SUBMISSION RESPONSE – FRAZER PARK QUARRY RESOURCE RECOVERY FACILITY

Thank you for your letter of 17 November 2016 notifying Council of the exhibition of the Frazer Park Quarry Recovery Facility (SSD 6518).

The subject site (800-900 Pacific Highway) is located directly north of the Central Coast/Lake Macquarie local government boundary. Prior to local government boundary adjustments, the subject site was located within the former Wyong Shire Council (WSC). Current operations on the site are undertaken pursuant to development consent (83/240) issued by the former WSC, as amended by Lake Macquarie City Council (LMCC) post boundary adjustment.

ANNEXURE E: INTERNAL ROADWAY LAYOUT (SHEET 1 OF 2)

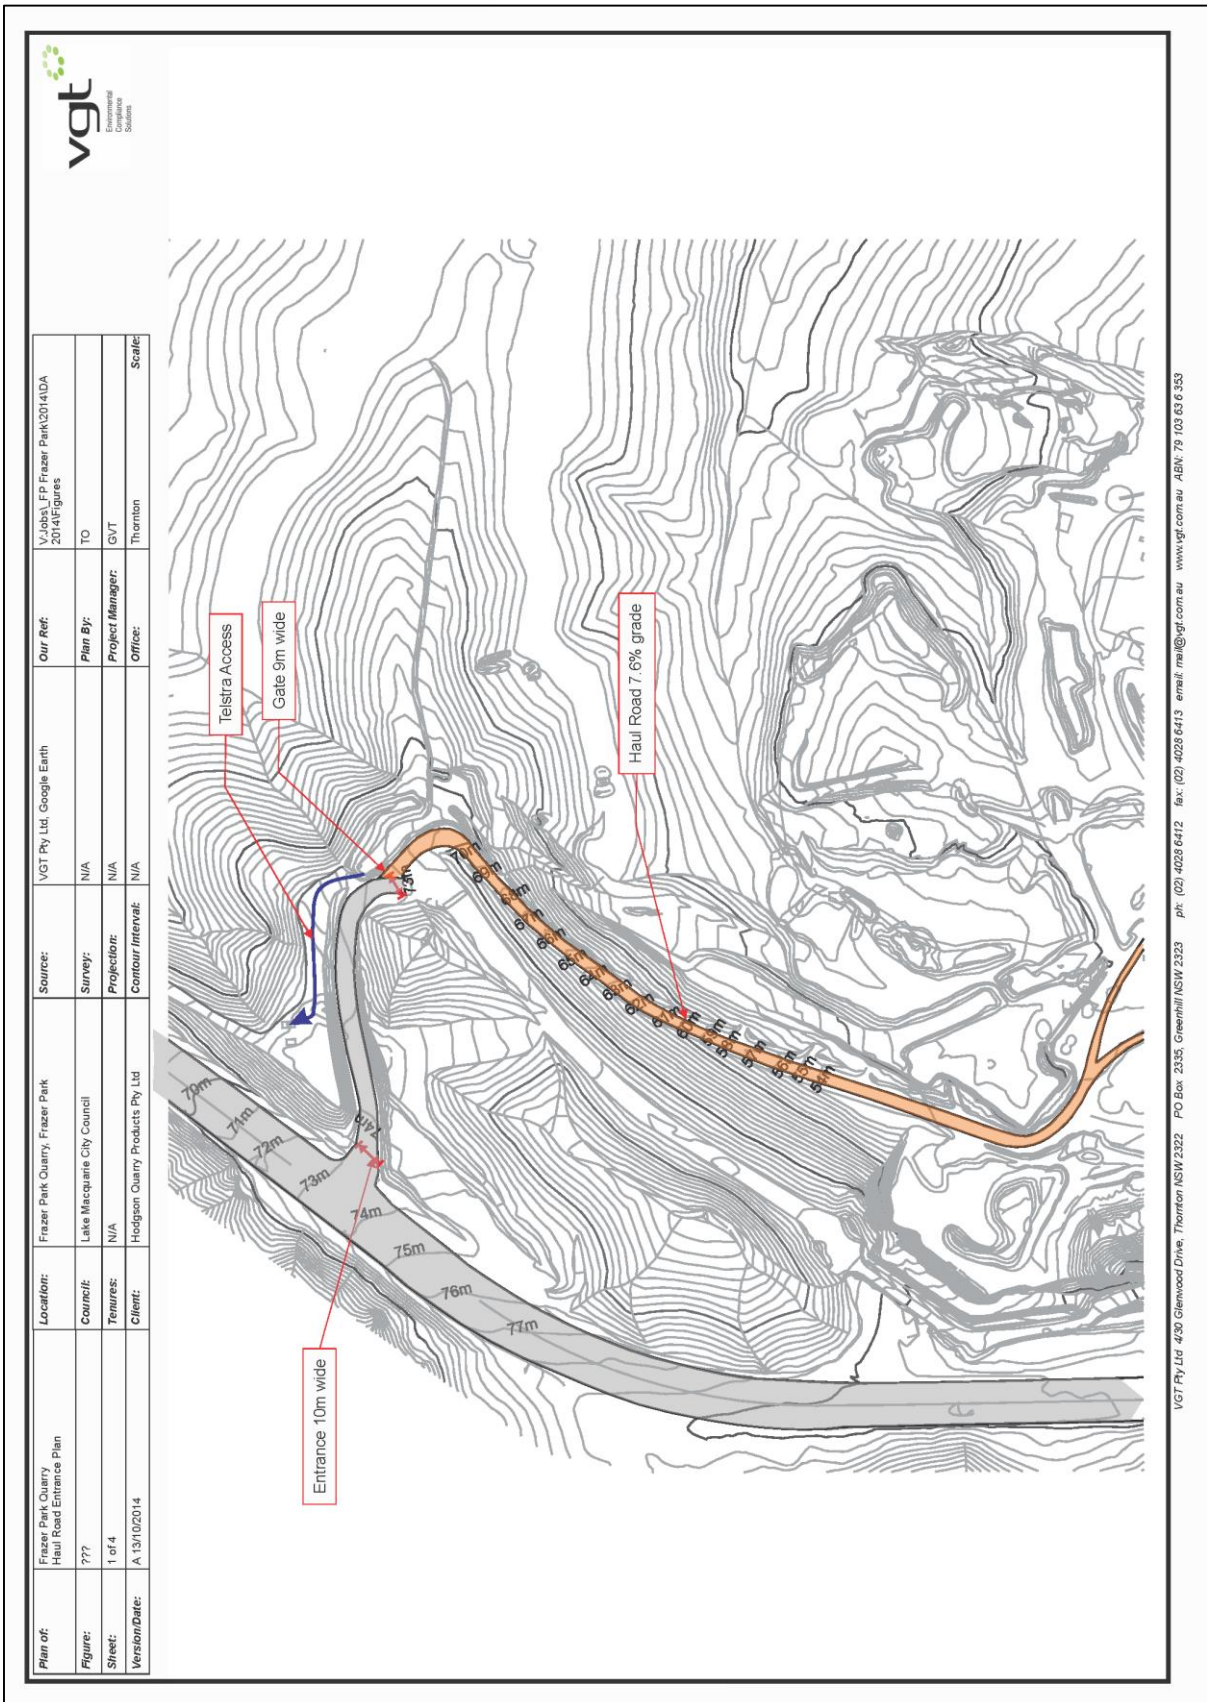
4. The limit of excavation adjacent the eastern boundary of the Pacific Highway should be restricted to ensure no adverse long term impacts on the Pacific Highway.

6. Fencing should be considered along the top of all excavations, to ensure that any person or animal will not fall.
7. The initial top of the first cliff is approx. 32m from the edge of the travel lane. This should have a safety barrier as approx. 20% of lateral displaced vehicles that haven't impacted a hazard are still mobile at a distance of 30m from the road.
